Design Review Panel 01  
Advice Summary

ALEXANDRIA PARK COMMUNITY SCHOOL  
DESIGN REVIEW 01 – 28 SEPT '17,  
320 Pitt St, Sydney (Department of Planning and Environment)

**Design Review Panel 01  
Advice Summary**

ALEXANDRIA PARK COMMUNITY SCHOOL  
DESIGN REVIEW 01 – 13 OCTOBER, 2017,  
320 Pitt St, Sydney (Department of Planning and Environment)

LANDSCAPE CONCEPT DESIGN

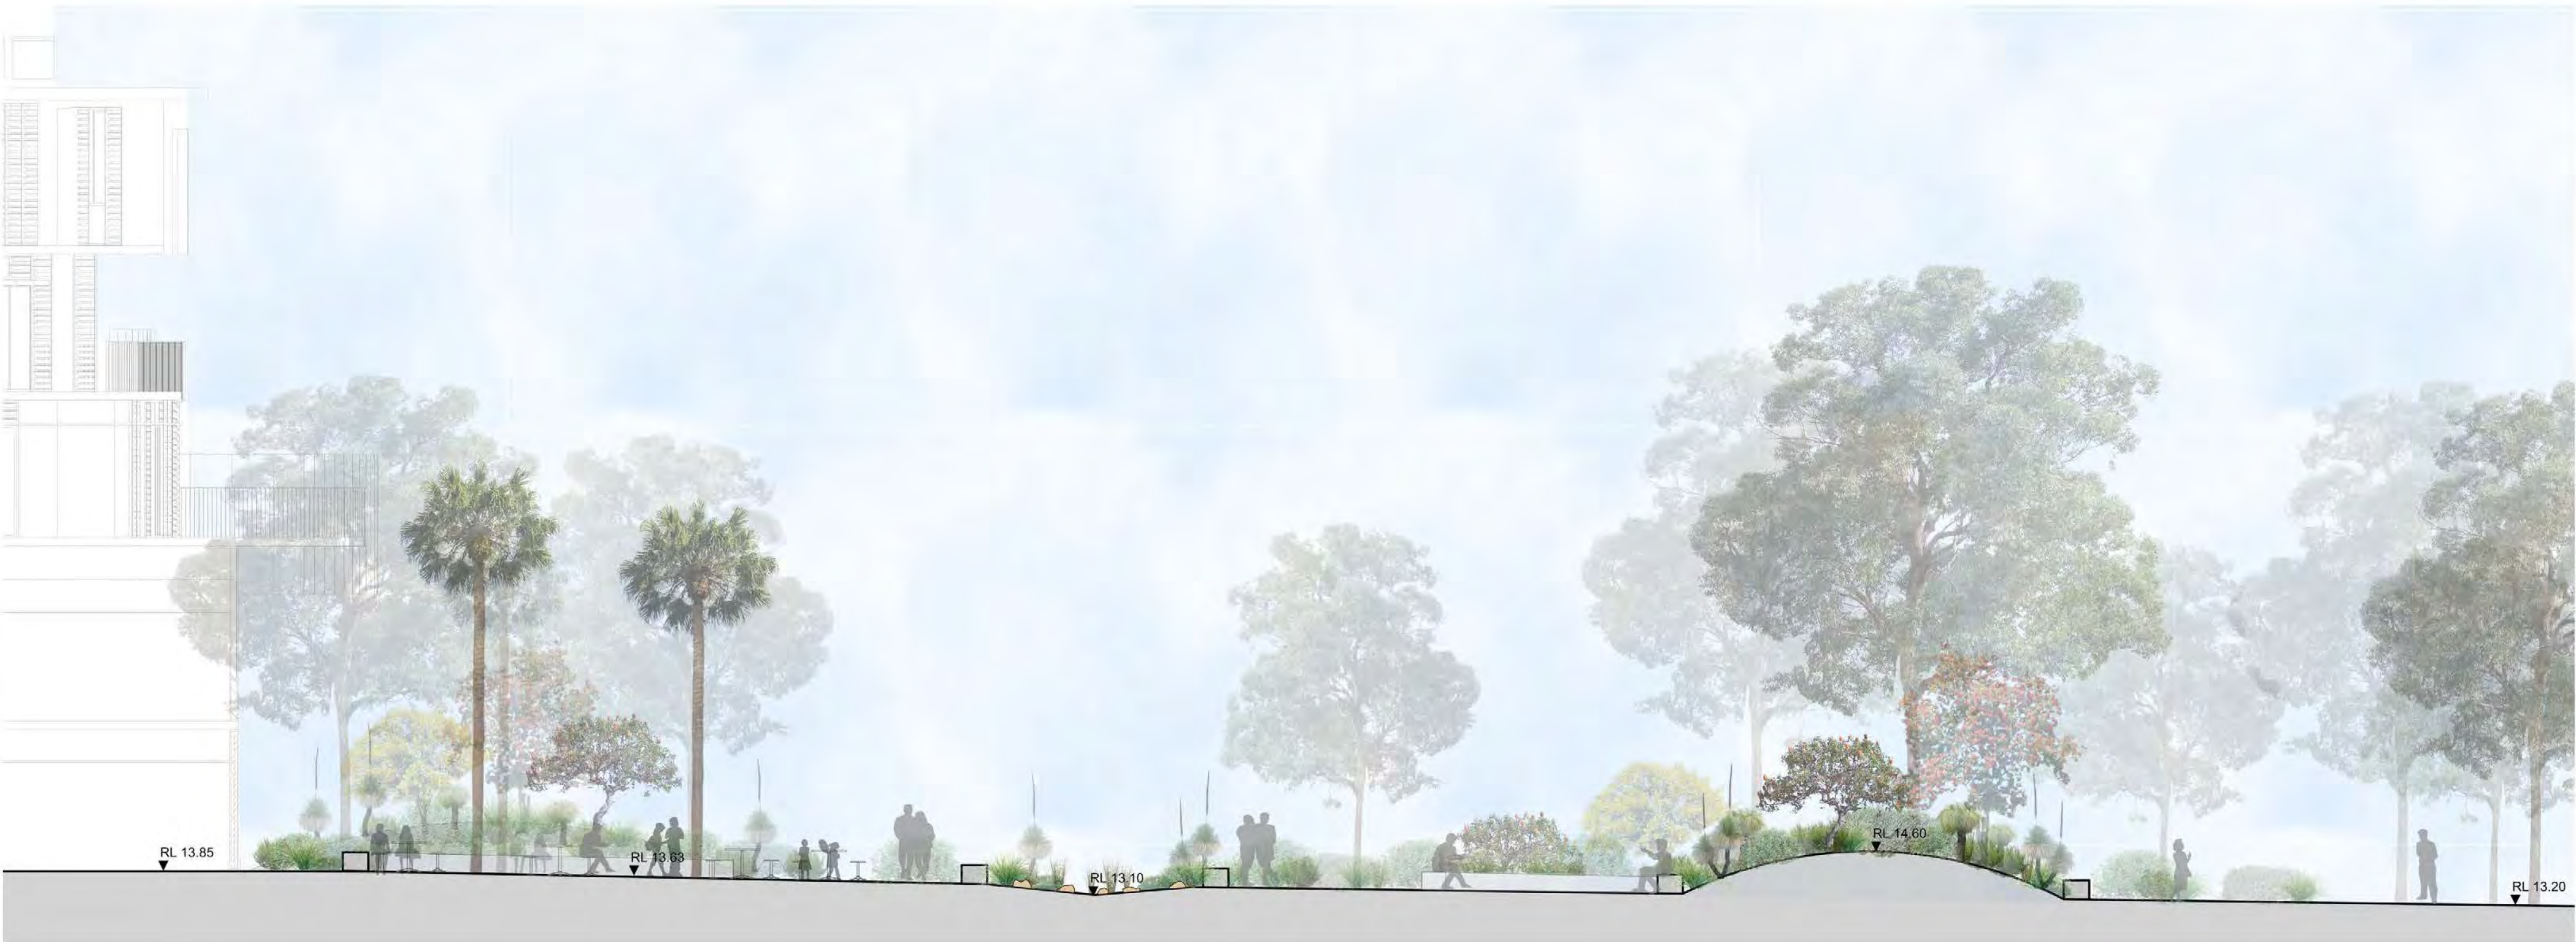
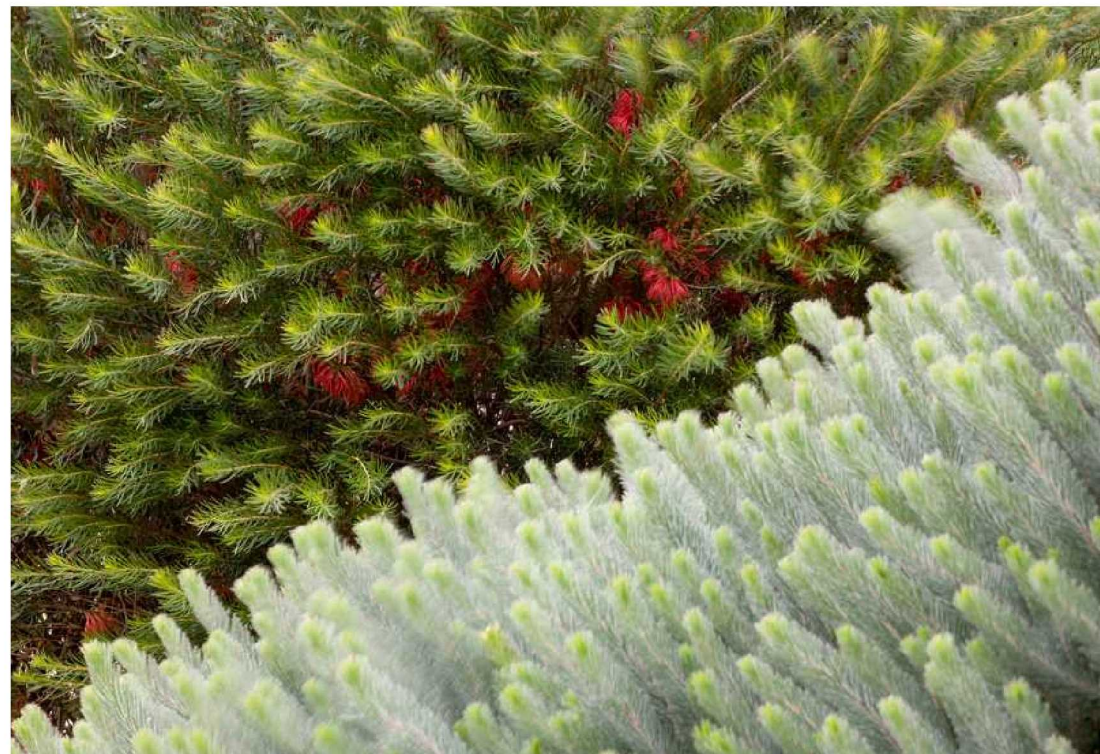
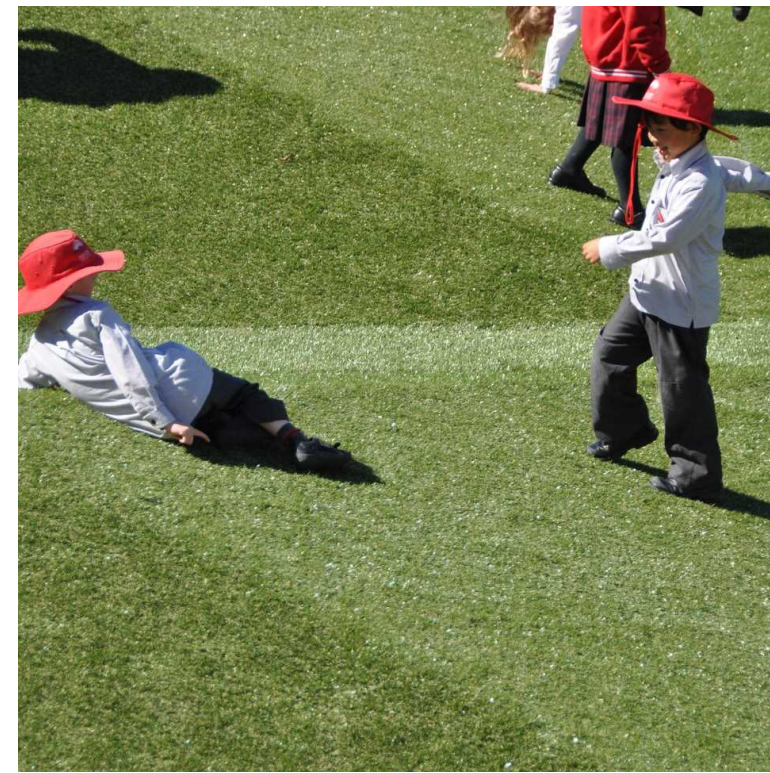
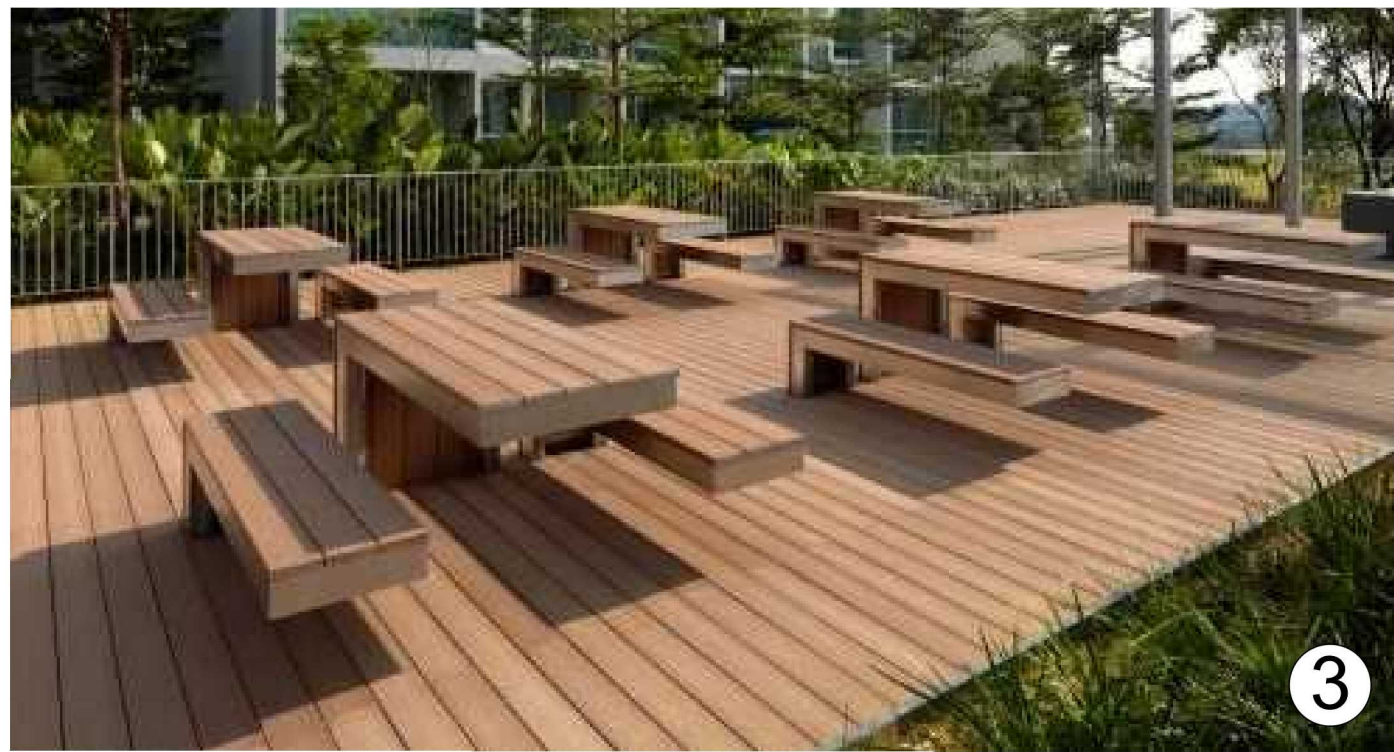
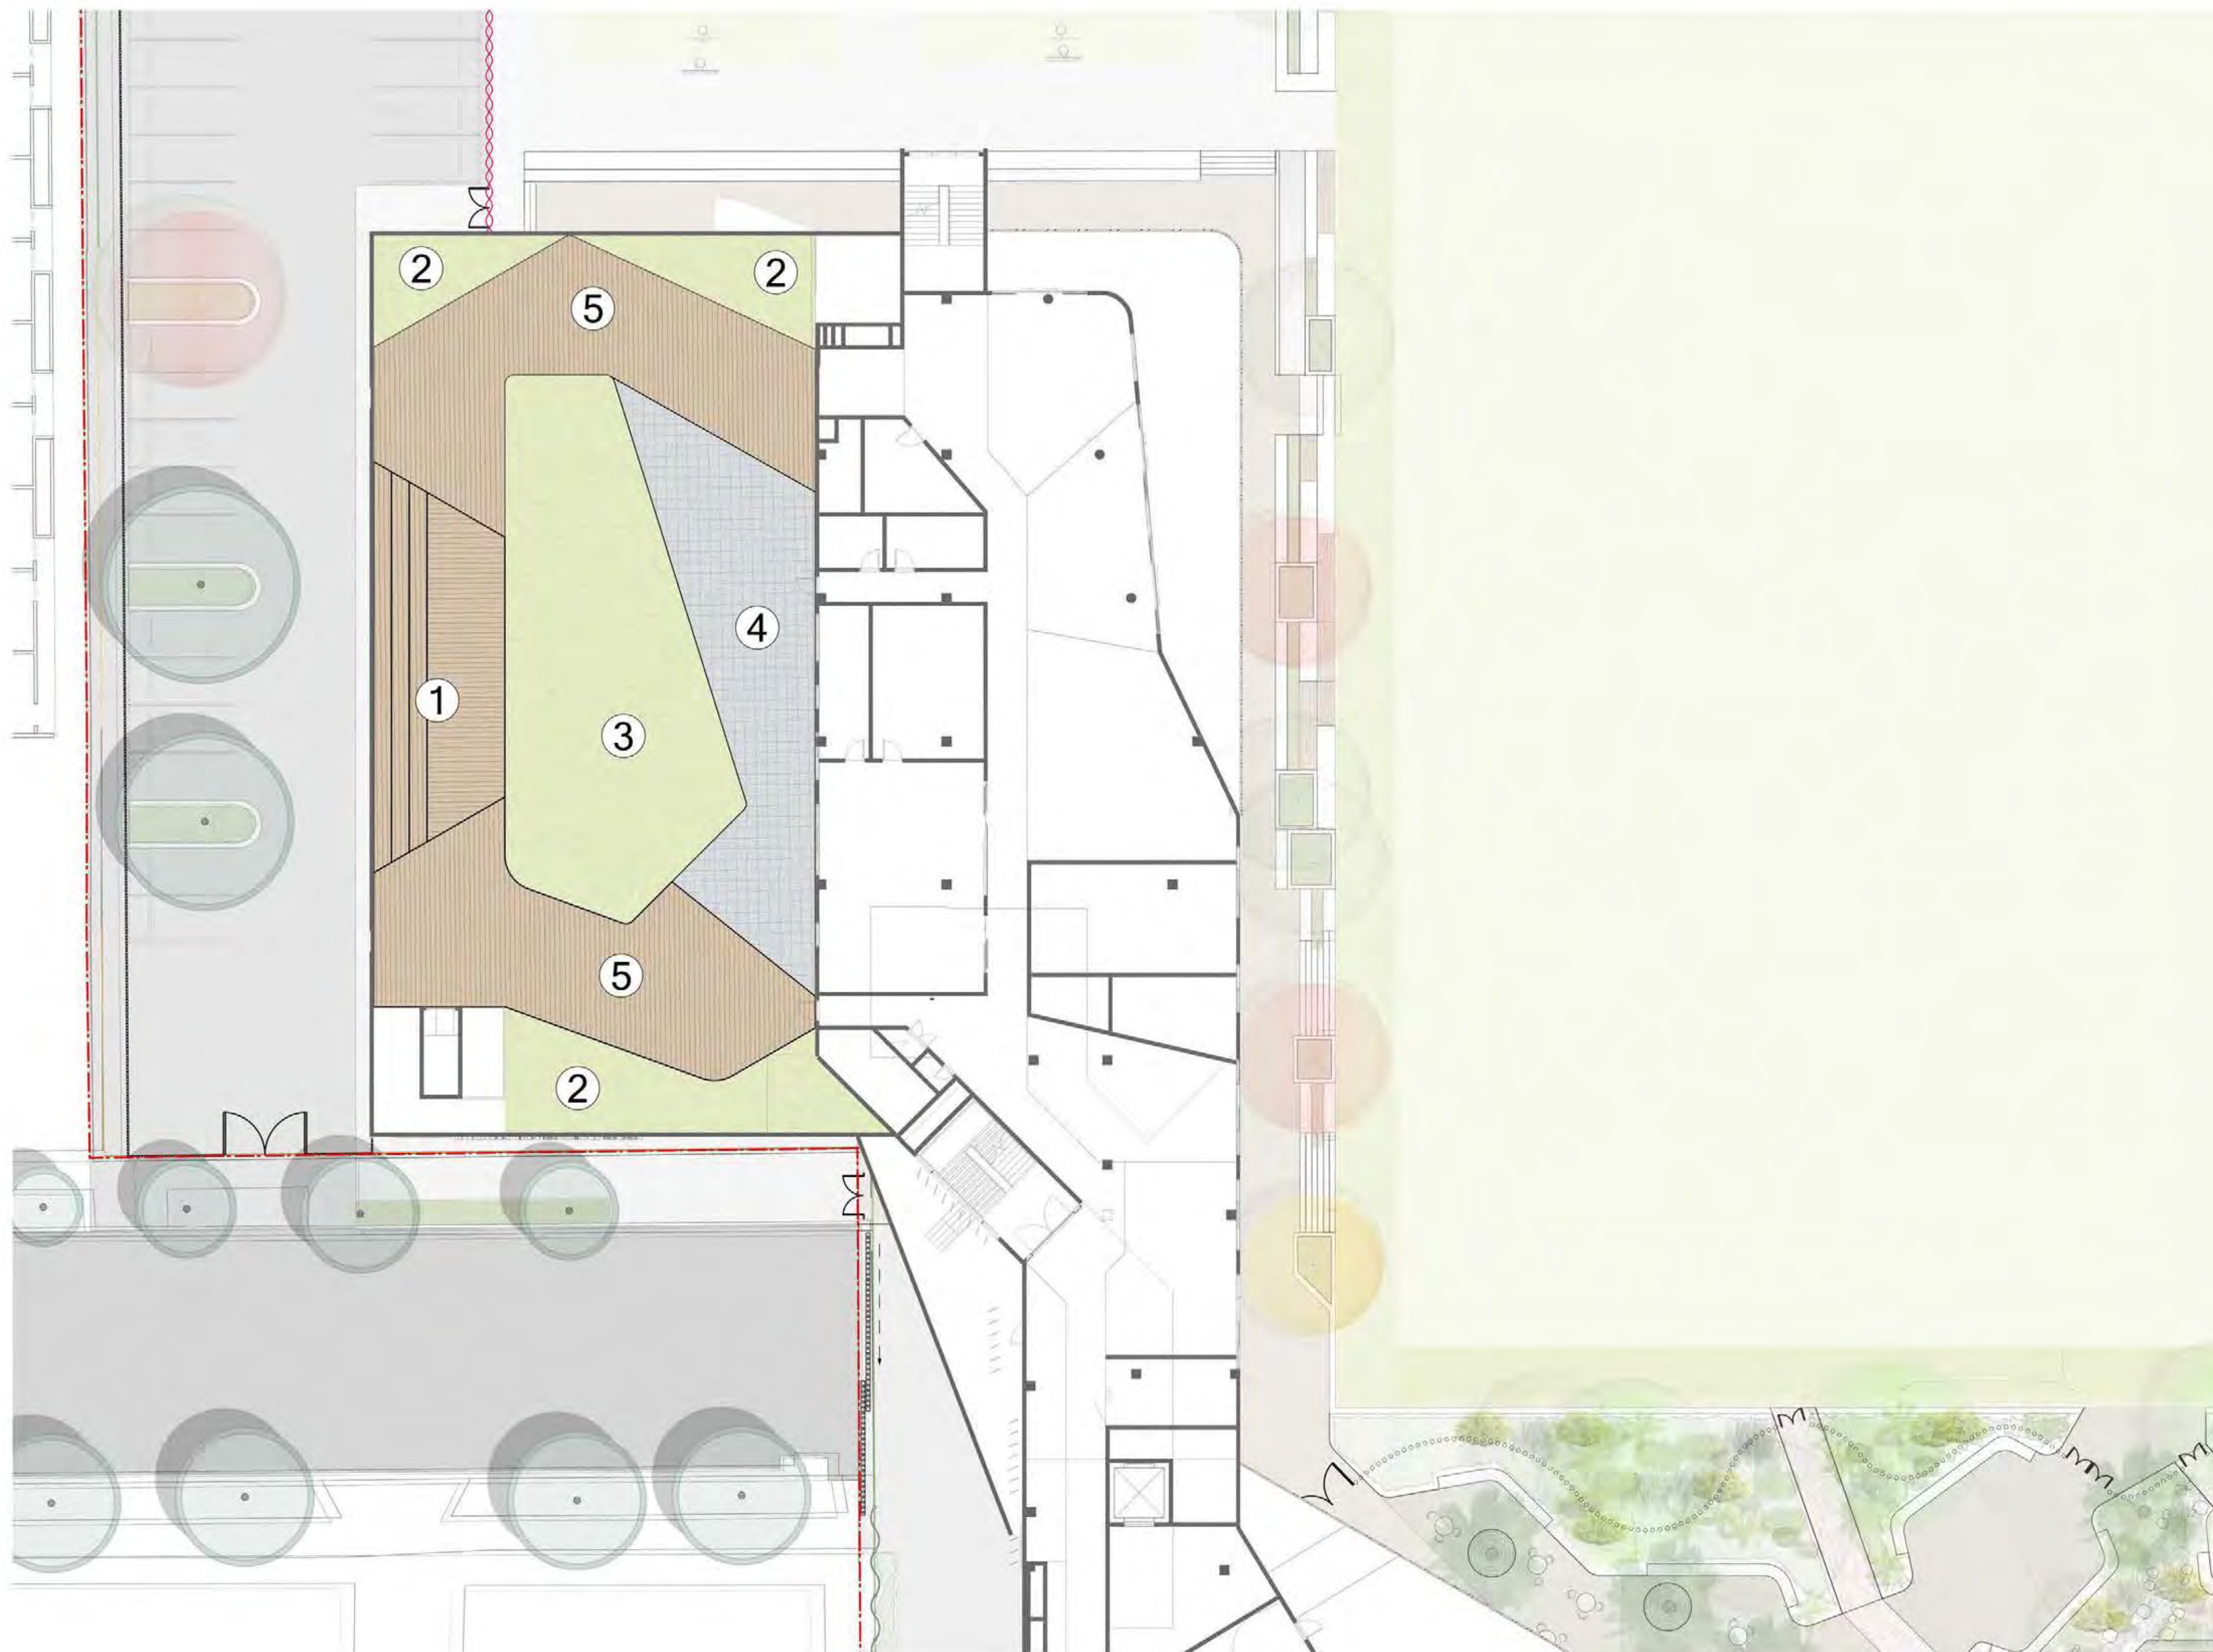
- Public art. A strategy for public art is required including commitment from DoE, program and budget.
- Landscape design. The Panel supports the landscape concept presented as a starting point. Include further detail to address integration issues noted in this letter. Visual connection from Park Road E/W across the site is supported. Increase shade to roof top areas.

- The Panel supports the landscape concept overall, noting that issues raised above will require further development of the landscape strategy (integrated fencing, rooftop open space design).
